From: Richard Brown
Sent: 09 September 2025 11:48
To: Planning
Cc: Kathryn Welch
Subject: FW: AB/135/20/OUT Land at Ford Road, Arundel
Attachments: Q8969_C_Arundel Road, Angmering LAP Area Plan.pdf; Q8969_C_Arundel Road, Angmering LAP Plan.pdf; Q8800_C_Arundel Road, Angmering Site Plan.pdf; Q8800_C_Arundel Road, Angmering LEAP Plan.pdf; Q8800_C_Arundel Road, Angmering LEAP Area Plan.pdf; Q12417_Ford Road, Arundel LAP 2-Plan.pdf

Application to approve First Schedule Clause 4 (Public Open Space Specification) in the Section 106 dated 26.11.21 (as amended) in relation to planning permission AB/135/20/OUT.

Subject: RE: AB/135/20/OUT Land at Ford Road, Arundel

DRAWING NO: Q8969_E

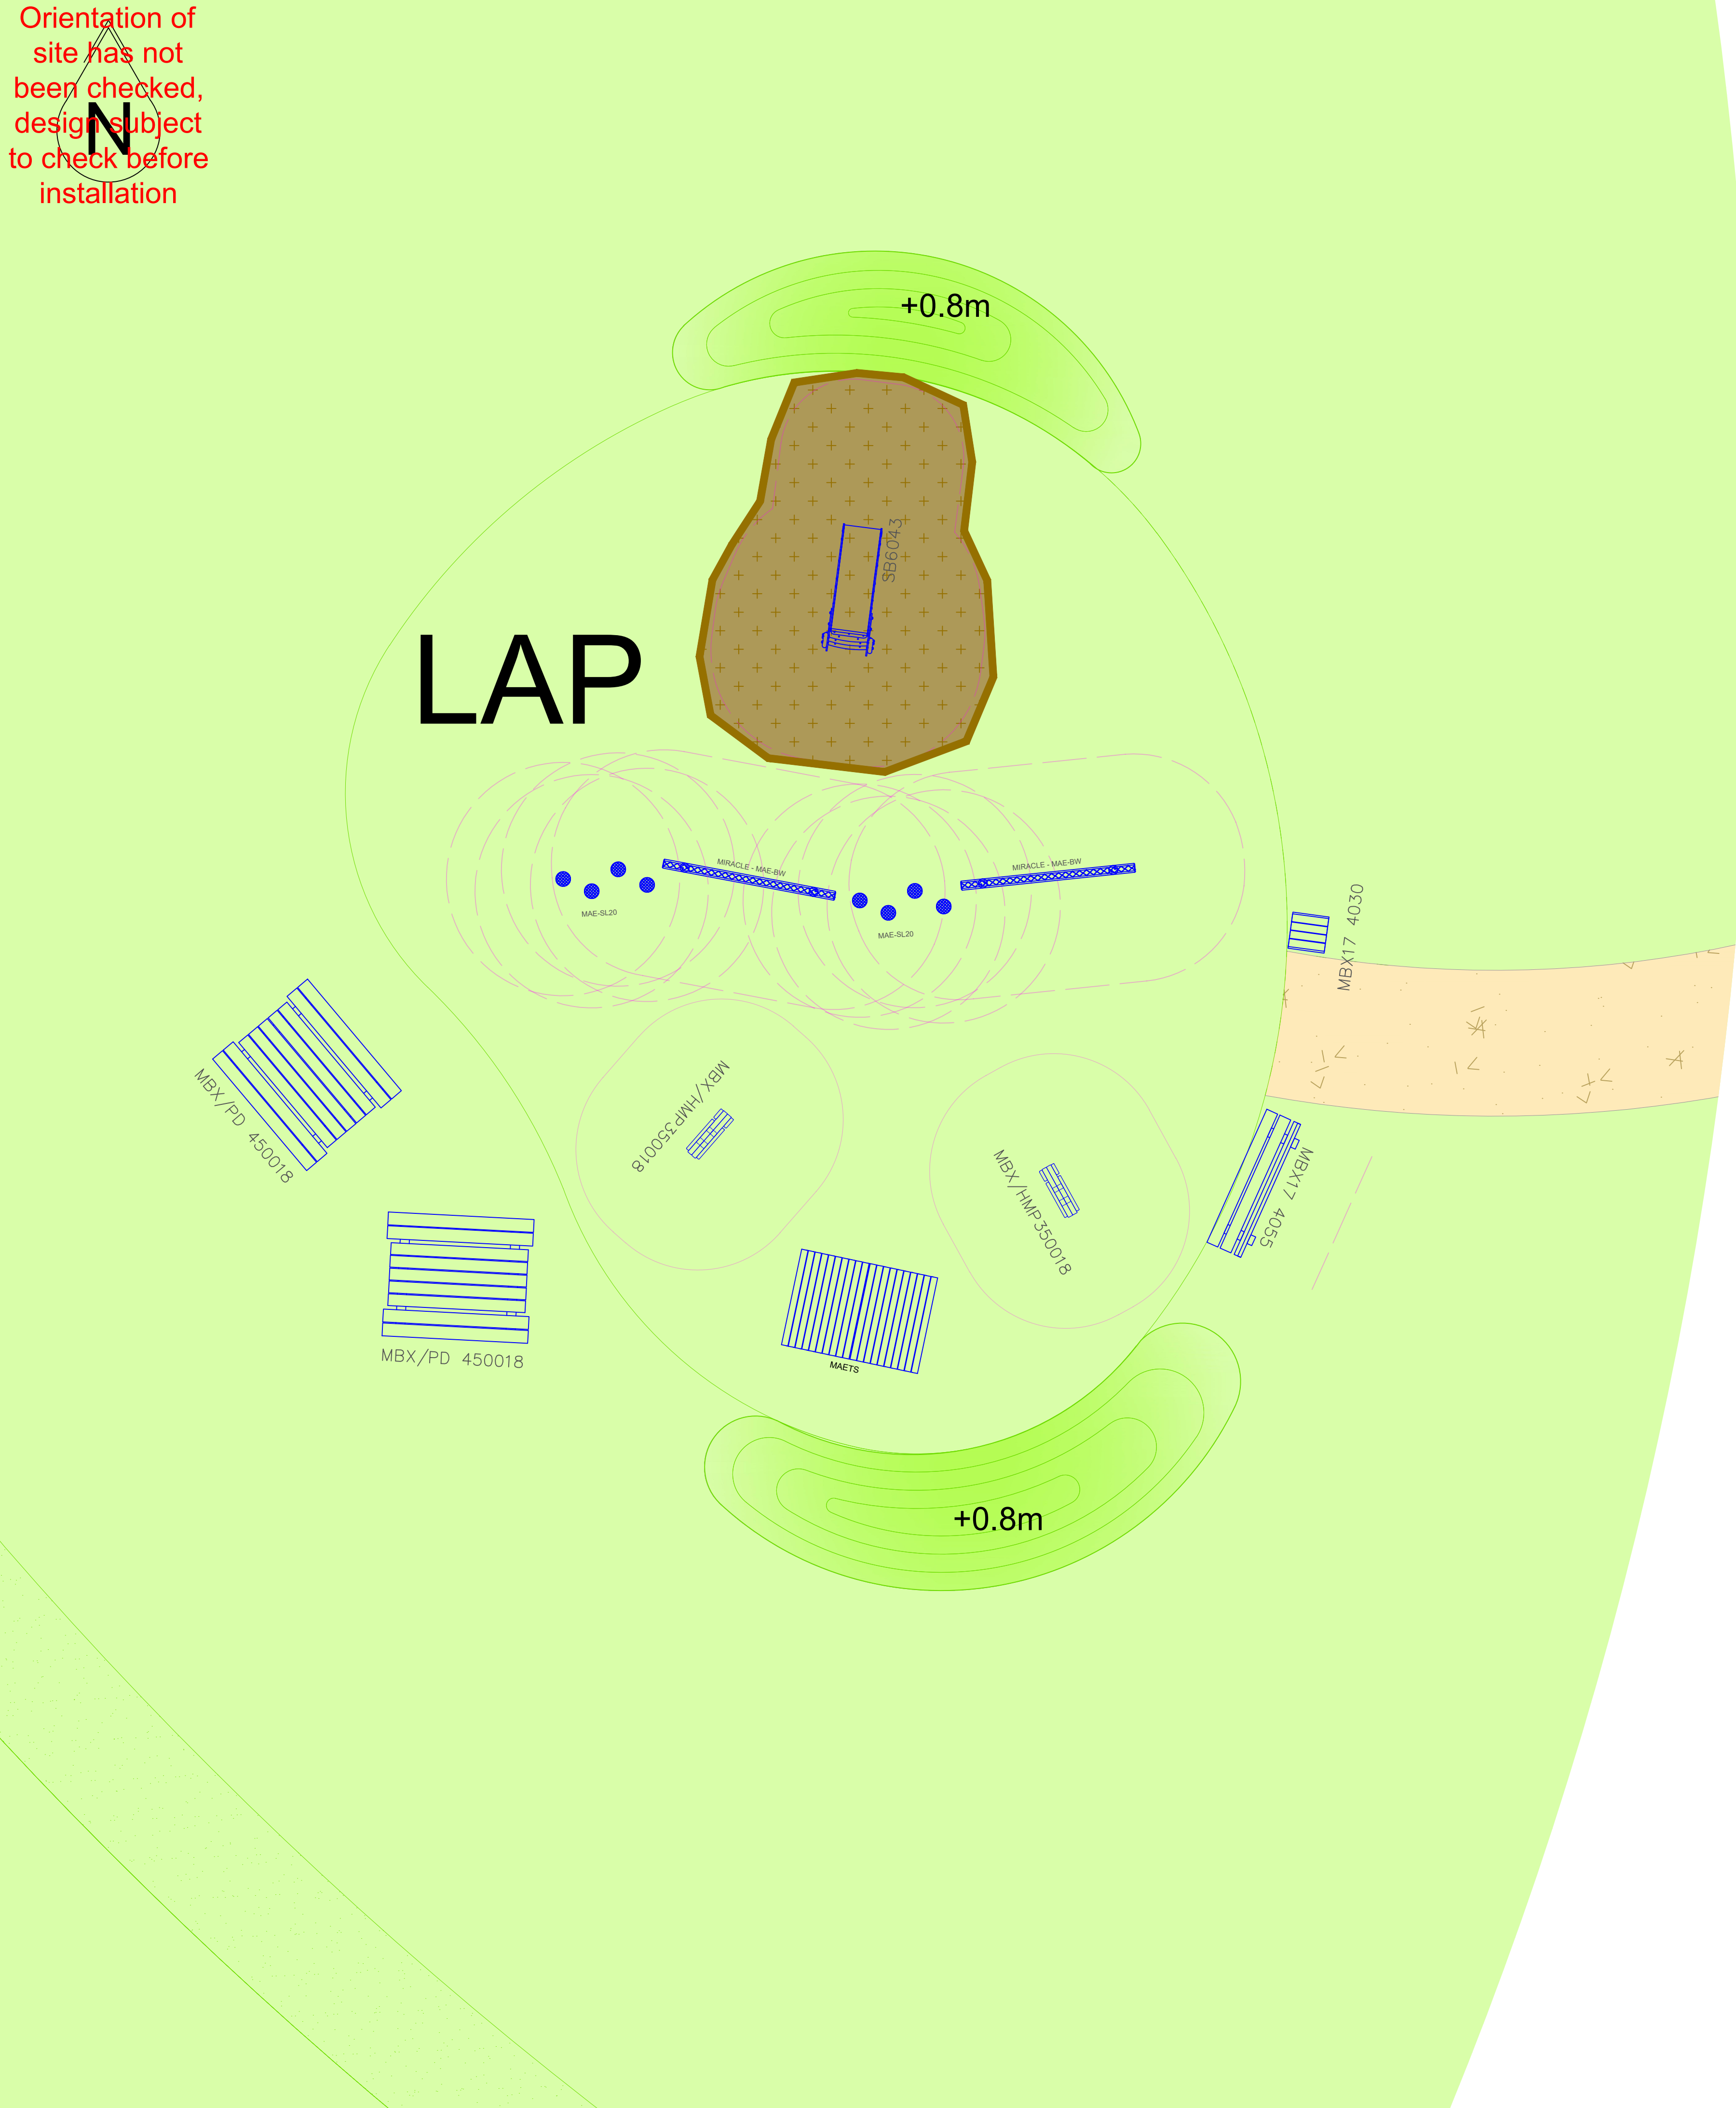
We agree with your reference to the Fields in Trust definition of a LAP. To expand on this, LAPs are intended for the very young venturing out under supervision and should be welcoming, semi-enclosed areas that incorporate natural elements such as landform, boulders, and basic climbing or stepping features. These spaces are not defined by the quantity of formal play equipment but by their suitability for informal, early-years play. We do not feel the requirements are overly onerous, and that they could very easily be incorporated within the scheme, without conflict with the RM approved documents.

The LAP (dwg no Q8969-A A) includes a mix of natural and formal elements, but again lacks soft landscaping and relies too heavily on formal play features. As noted above, LAPs should be natural, informal spaces with features such as mounds, boulders, logs, and stepping stones, supported by seating and bins.

- We have now introduced a new LAP at the north of the site.
- We have moved the basket swing from the previous submission of the LAP onto the LEAP.
- Replaced the basket swing from the LAP with a slide.
- We have twisted the current swing in the LEAP and inserted the basket swing from the LAP on the side.
